Ottawa, November 26, 2024  
No.: 1000-Tawadina-YME-L5

**Reference:** City of Ottawa File D07-12-22-0127 (375 Codd's Road).

**Subject:** Re-examination of waterproofing requirements in report 55-BWI-R1 for foundations placement above the water table and recommendations in connection with infiltration chamber at a 1.3 m setback from the wall of the proposed building.

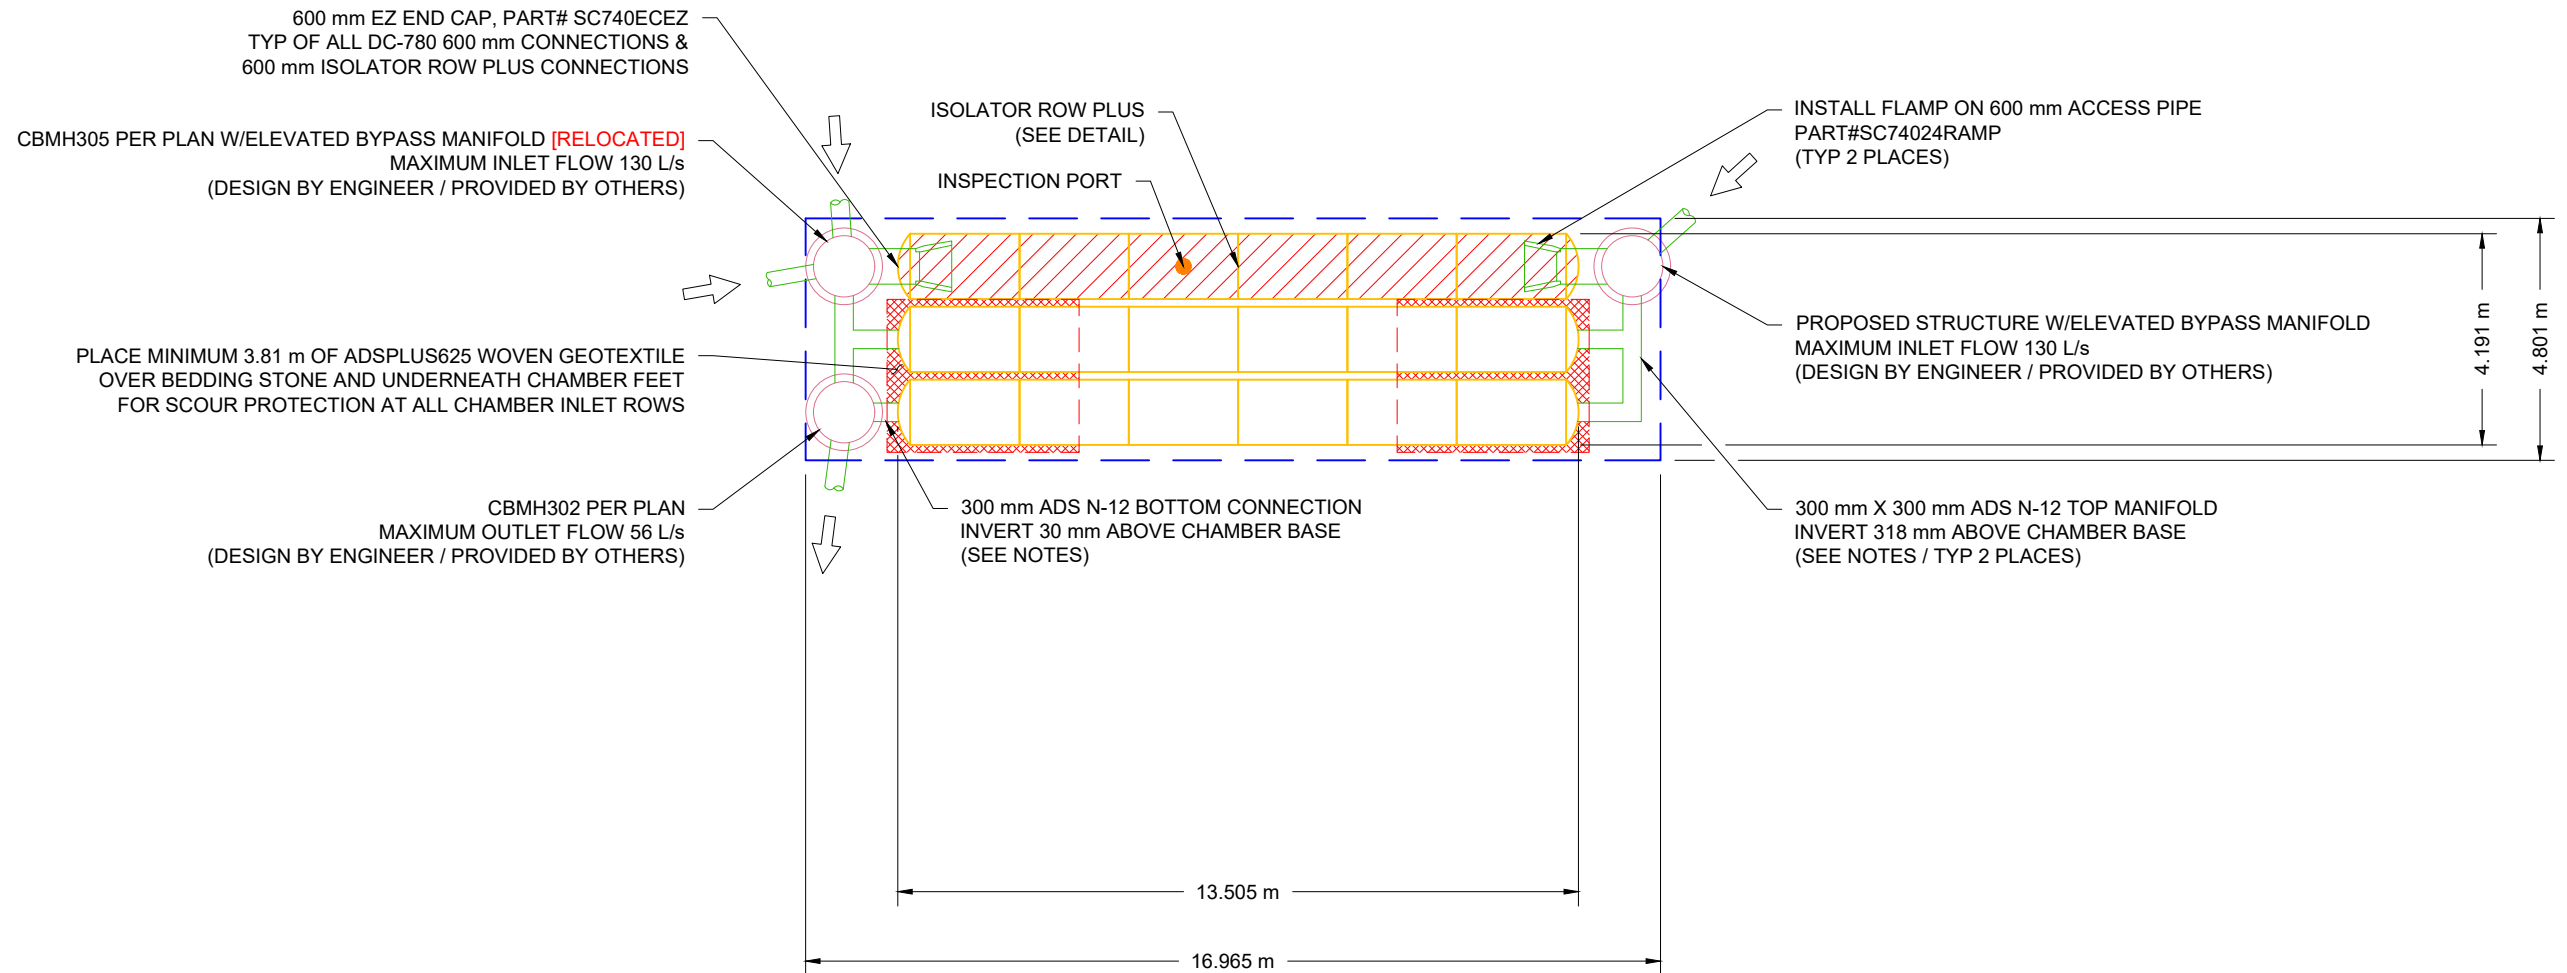
1. Top of bedrock: 87.23;
2. Underside of Foundation (USF): 86.59
3. Underside of the infiltration chamber: 86.46
4. water table elevation: 85.36

To minimize the impact to the building from the subject chamber:

- Provide a clay seal between the foundation wall and the chamber;
- Wet of optimum water content for proctor density of silty clay is estimated to be around 19 %. Natural water content for clay is generally greater than 19%.
- Clean the bedrock surface using compressed air;
- Because of the proximity of the wall and the chamber only light compaction is to be applied to the clay seal. Provide a single pass of compaction equipment on 30 cm lifts of silty clay having approximately 19% of water content *and*;

For protection of the bearing surface of bedrock along the subject chamber:

- Use a saw to cut the bedrock at the edge of the chamber to allow placement of the chamber at its proposed elevation. Do not attempt ripping.
